EPC STORMWATER REVIEW COMMENTS  
IN ORANGE BOXES WITH BLACK TEXT

# GRADING AND EROSION CONTROL PLAN

## FOR 168 TRAINING FACILITY

### GRADING & EROSION CONTROL PLAN COVER SHEET

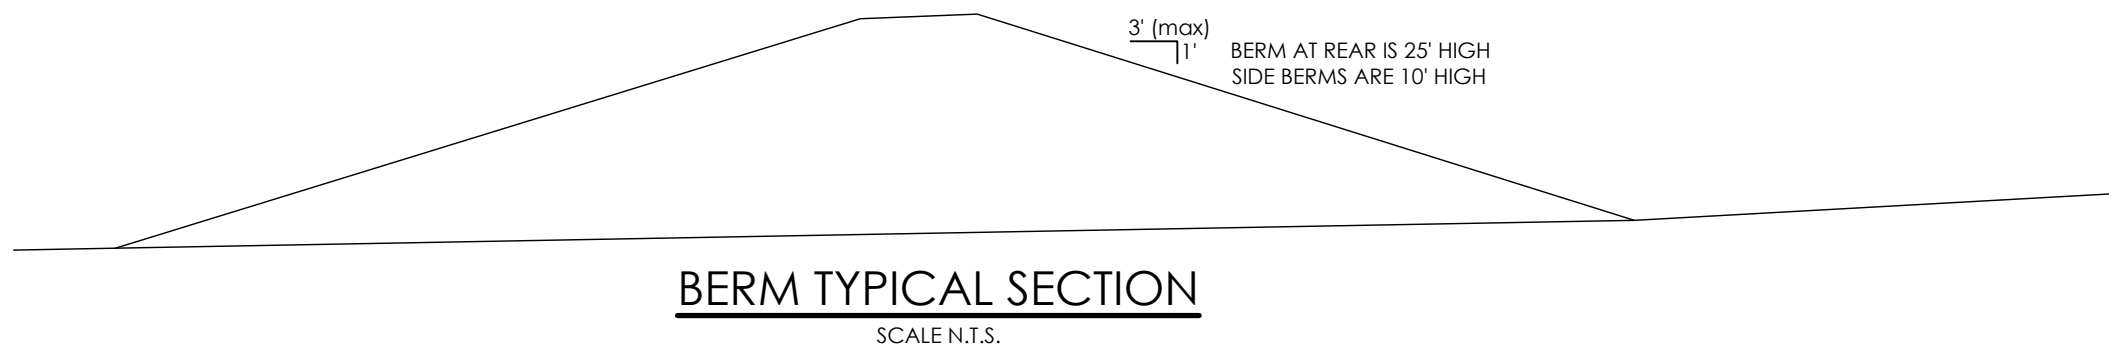
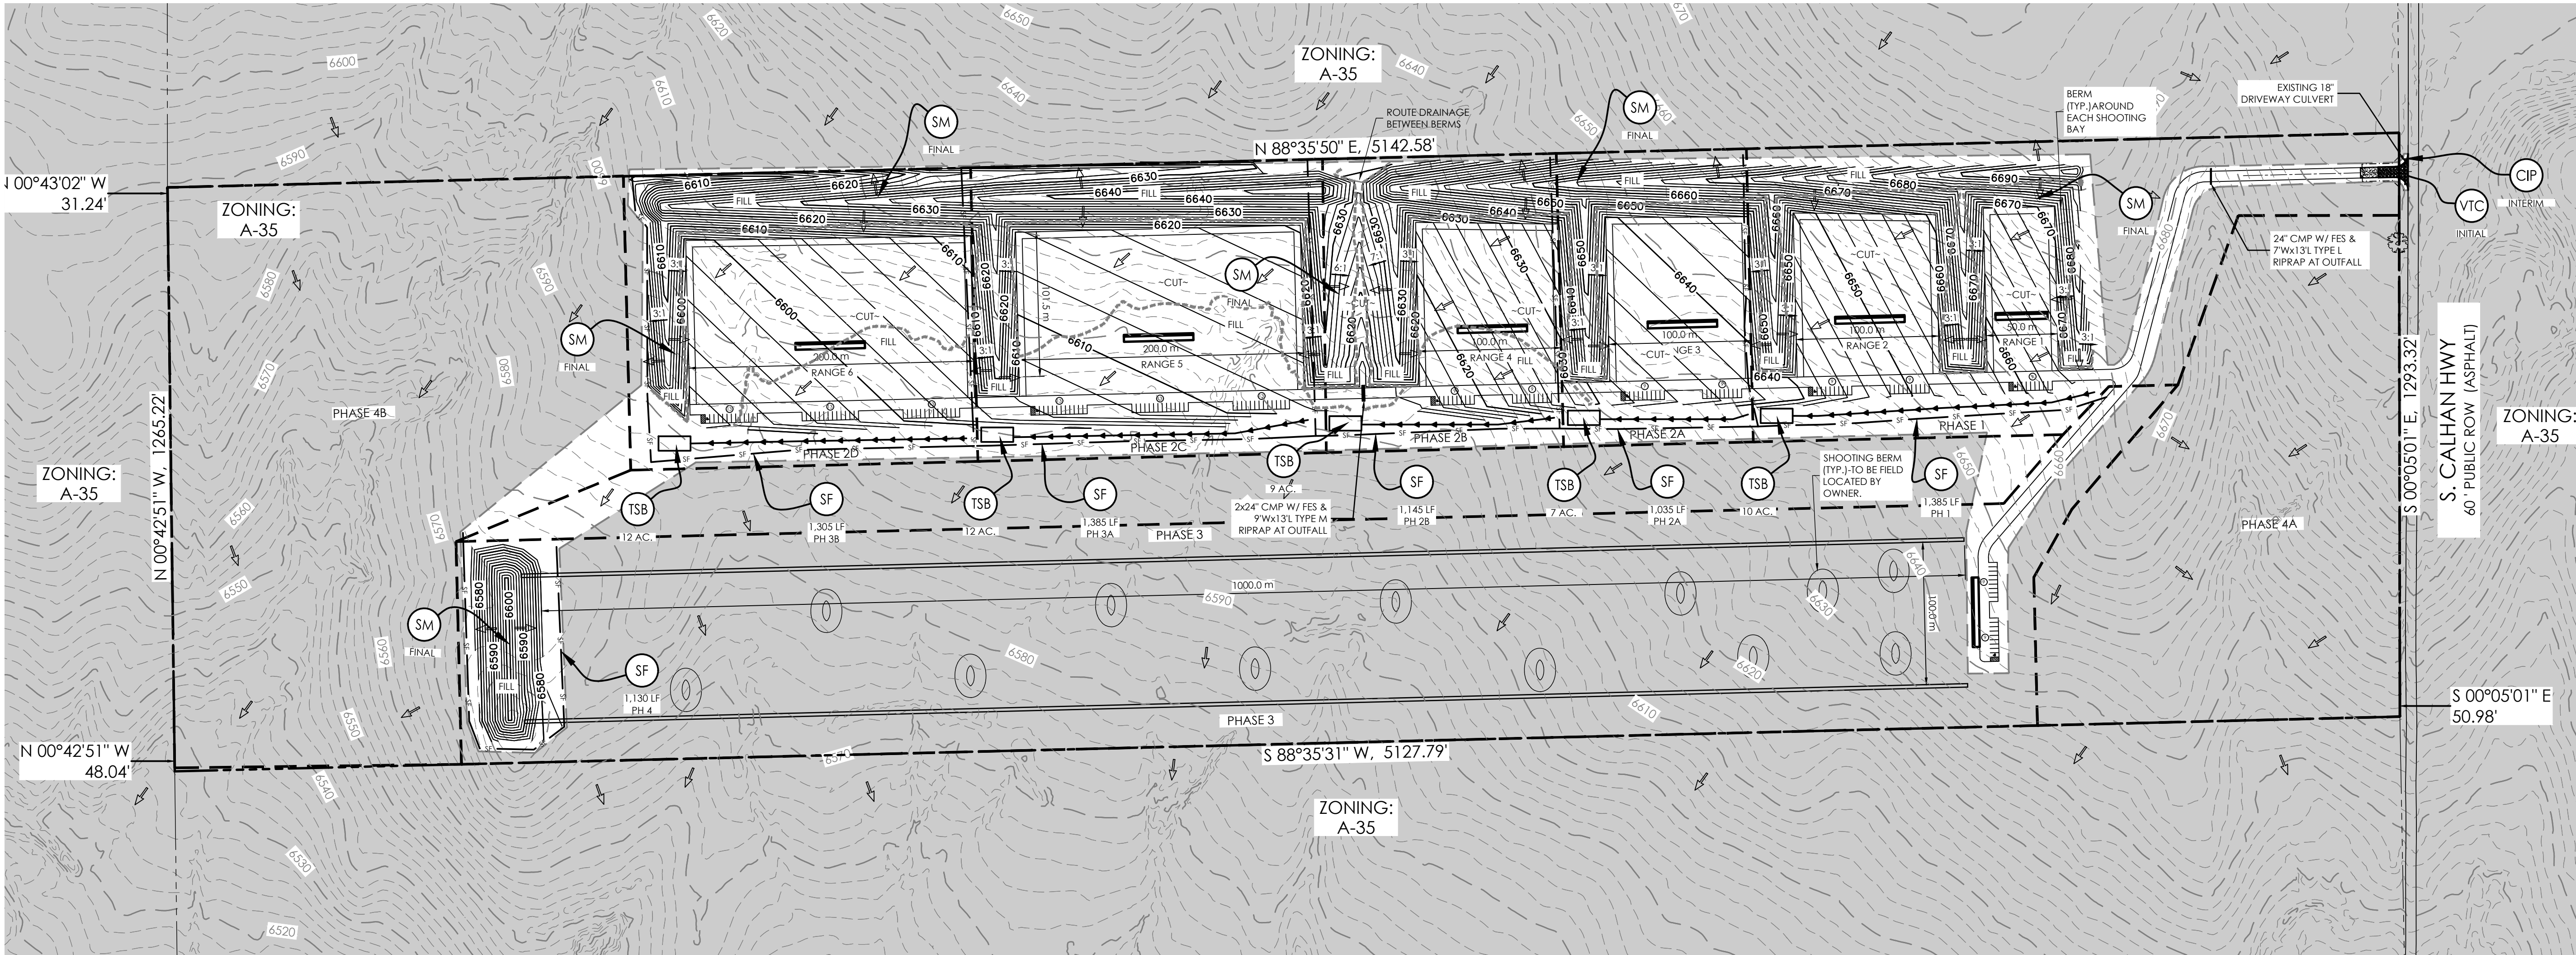
Unresolved from Submittal 1: Please provide ditch sizing including minimum depth required.
